ED23/19174
Parcel 45595
DTQ:DTQ

Maryvale Solar Farm SSD-8777 Modification 2

Property: Lots: 122, 130, 173 & 182 DP: 754318, Lot: 1 DP: 723474, Lot: 1 DP: 1031281, Lot: 2 DP: 573426, Lot: 1 DP: 1006557, Lots: 11 & 12 DP: 1260757,
No's 87, 121 & 265 Maryvale Road & 801 Saxa Road MARYVALE
Modified Application: Maryvale Solar Farm

APPENDIX 6: ROAD UPGRADES AND SITE ACCESS

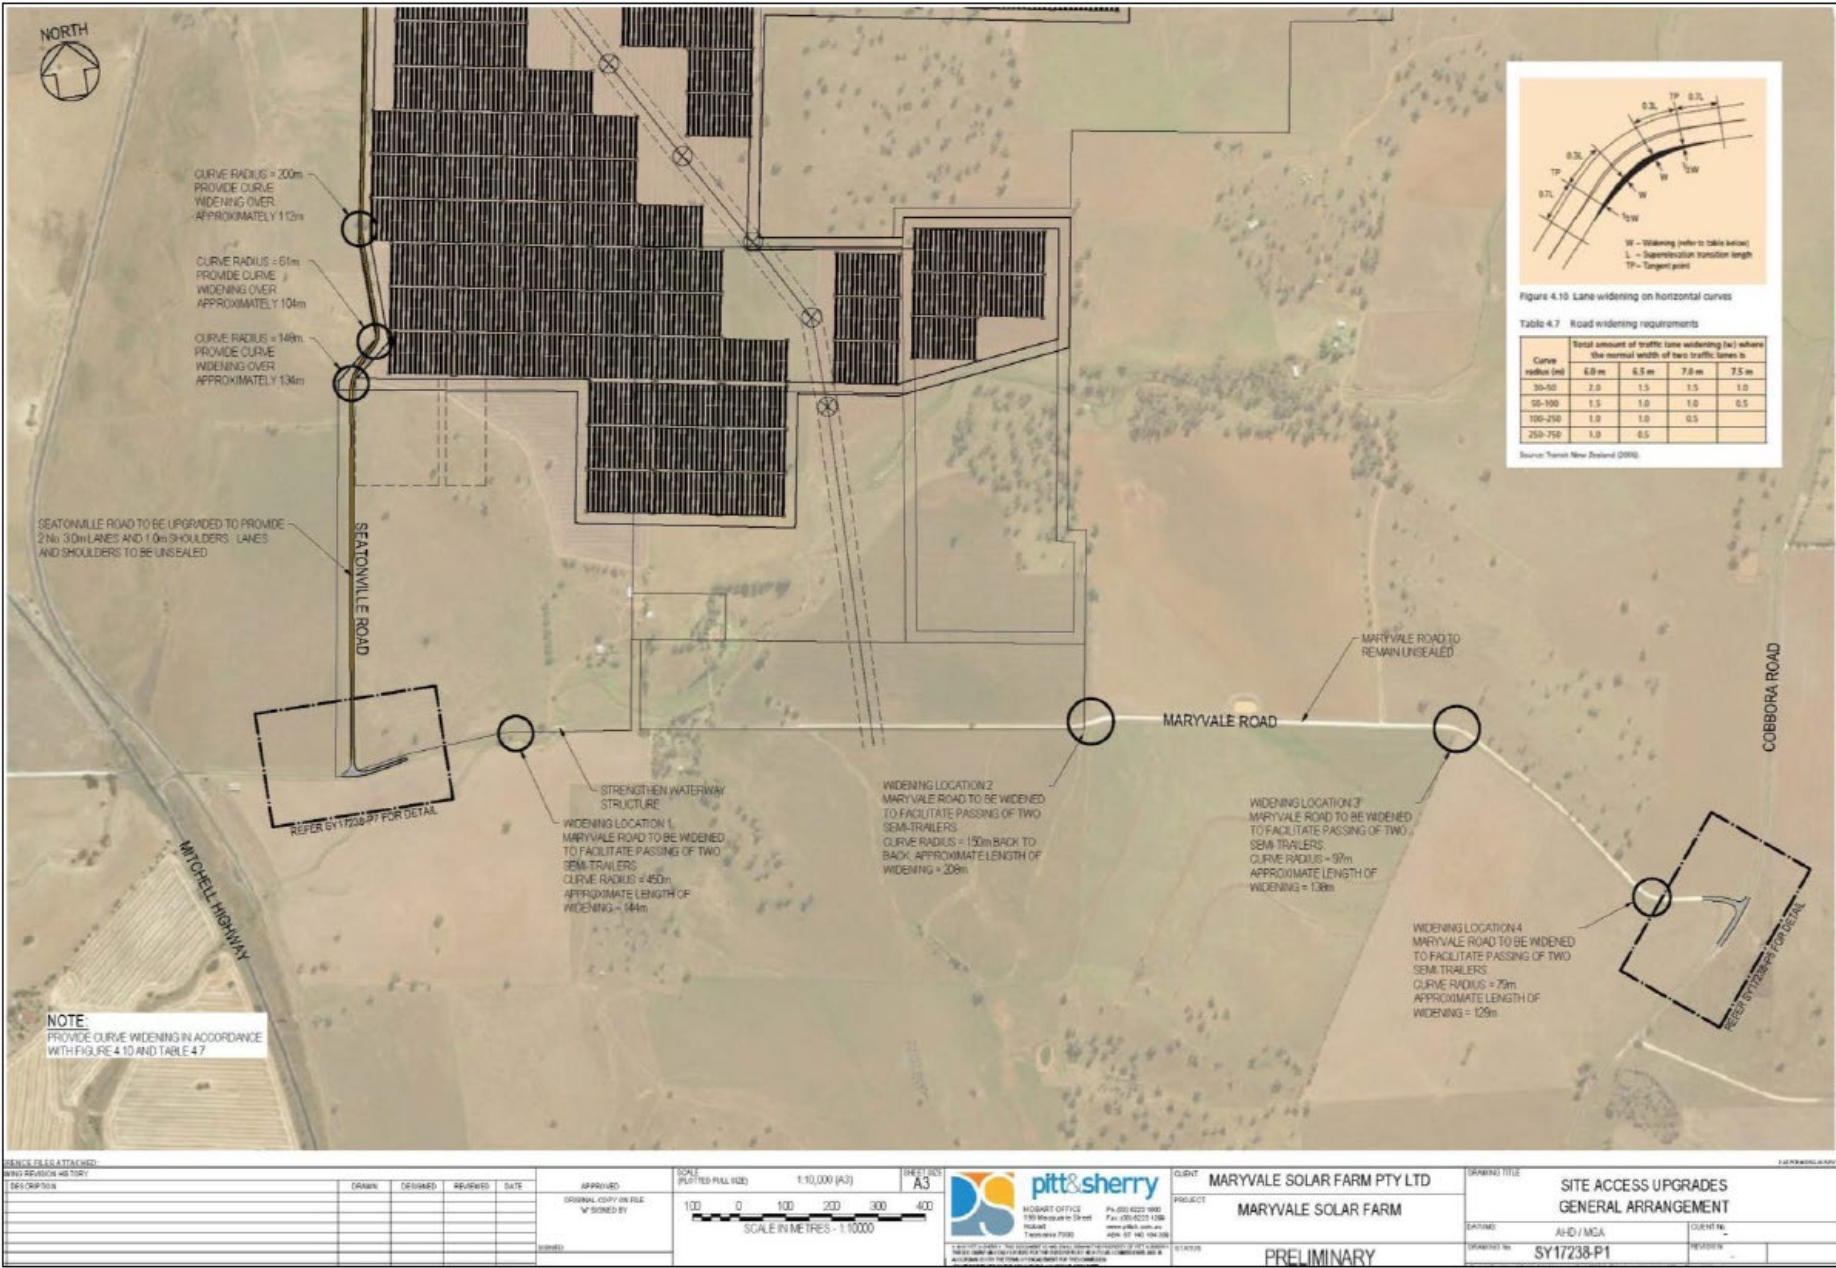
It should be noted that Cobbora Road located to the east of the subject site was renamed recently to Saxa Road, as such this change is reflected in Appendix 6 (show below). The other proposed changes are to clarify the works required, with the four sections listed on Maryvale Road being removed as these would be identified when the road is to be sealed, as Condition 5 requires the proponent to undertake the works to Austroads standards and to Councils satisfaction. These four sections would be subject to design standards and Council acceptance at that time.

Similar for the widening of three curves on Seatonville Road and strengthening the culvert on Maryvale Road, these would be undertaken to the satisfaction of Council and added a requirement to widen the culvert.

Road/Intersection	Upgrade Works
Saxa Road	<ul style="list-style-type: none"> Widen and strengthen the Saxa Road from the intersection with the Mitchell Highway to the intersection with Maryvale Road to the satisfaction of the relevant Road Authority.
Saxa Road/Maryvale Road intersection	<ul style="list-style-type: none"> Upgrade and widen the intersection, including short auxiliary left turn [AUL(s)] treatment on Saxa Road
Maryvale Road	<ul style="list-style-type: none"> Construct and provide a 7.2metre wide bitumen sealed road to the remaining unsealed section of the Maryvale Road prior to the commencement of Solar Farm construction works and to the satisfaction of the relevant Road Authority. Widen and strengthen the waterway structure as noted in the below figure.
Maryvale Road/Seatonville Road Intersection	<ul style="list-style-type: none"> Upgrade intersection, as identified in the below figure; and Sealing Seatonville Road for 30 metres from the intersection with Maryvale Road.

Seatonville Road	<ul style="list-style-type: none"> Widen and gravel resheet the Seatonville Road (to a minimum width of 6metres and to a minimum depth of 0.1metres) to allow for two all-weather heavy vehicle movements from the intersection with the Maryvale Road to the project site entrances, works to be undertaken to the satisfaction of the relevant Road Authority. Widen three identified sections in accordance with the curve radius requirements noted in the below figure.
Site Access	<ul style="list-style-type: none"> Construct two new site access points off Seatonville Road, and upgrade the intersection of Seatonville Road and Bakers Lane, with Rural Property type treatments to cater for largest vehicle accessing the site.
